Silvertown Tunnel Development Consent Order

London Borough of Hackney

Post-hearing submissions including written submission of oral case in relation to the Issue Specific Hearing on traffic modelling, forecasting, user charging and economic issues

PINS Reference		
Document Number	LBH 06	
Authors	LB Hackney, Project Centre, GVA	
Revision	Date	Description
0	January 2017	Deadline 3 Version

Figure A - 1: ATC sites in the Area of Influence

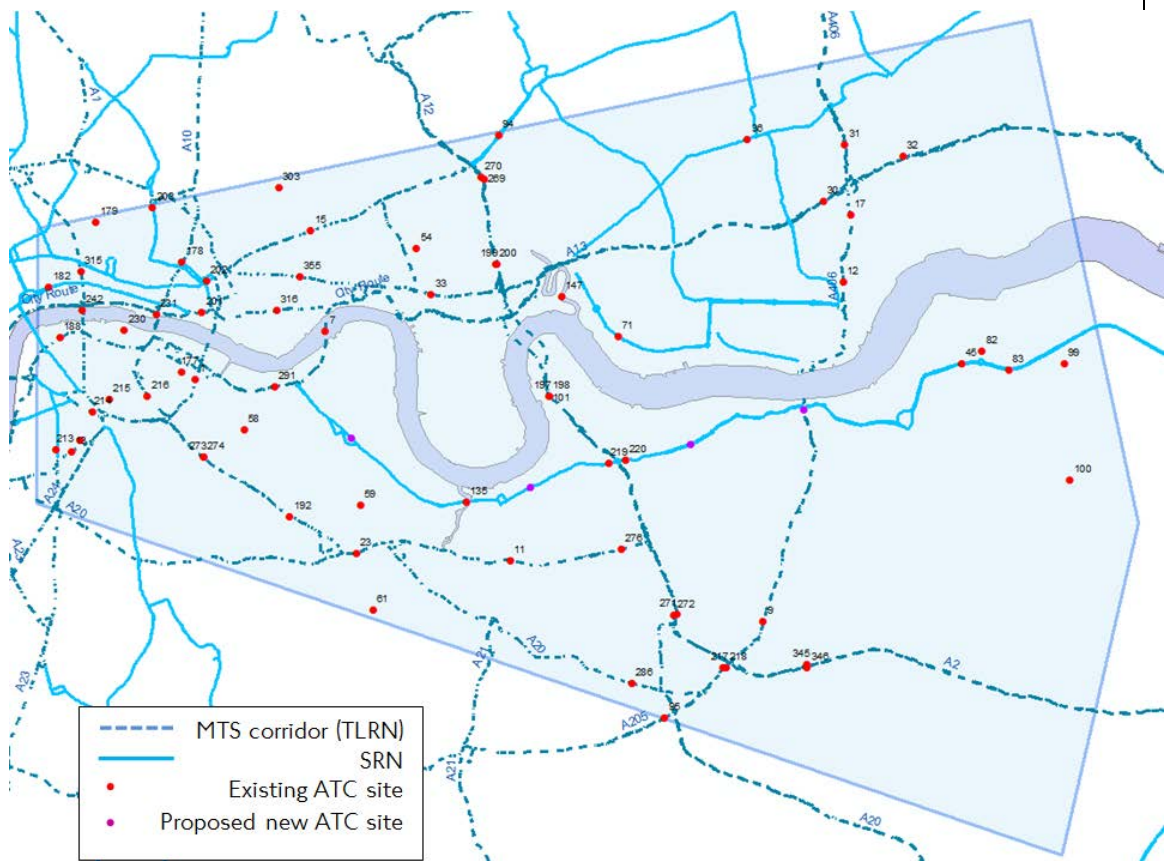
- 2.6 TIMS at A.2 and Figure A-1 shows the A102 Homerton High Street within the borough to be classed as a Strategic Corridor. Within TIMS this means the triggers are very high, especially for HGV's, where an increase of >25% would be needed to trigger as RED for consideration by STIG.

2.15 TIMS Figure A-1 ATC sites in the Area of Influence, shows the AOI is now larger than illustrated in the Monitoring Strategy (Fig 3-1). LB Hackney assume the newer version is correct and seek clarification of this from TfL together with an update of all figures to show consistency. As previously raised, LB Hackney thinks the AOI should extend further north to include the borough.

2.16 Related to this, the Monitoring Strategy Figures 3-1 and A-1 need to be reviewed and updated to show the new monitoring sites as they do not reflect those within Table A-1 Initial Traffic Monitoring Plan. Figure A1 in the Monitoring

Strategy shows a junction monitoring site on the A12 in Hackney. This does not appear to be reflected in tables.
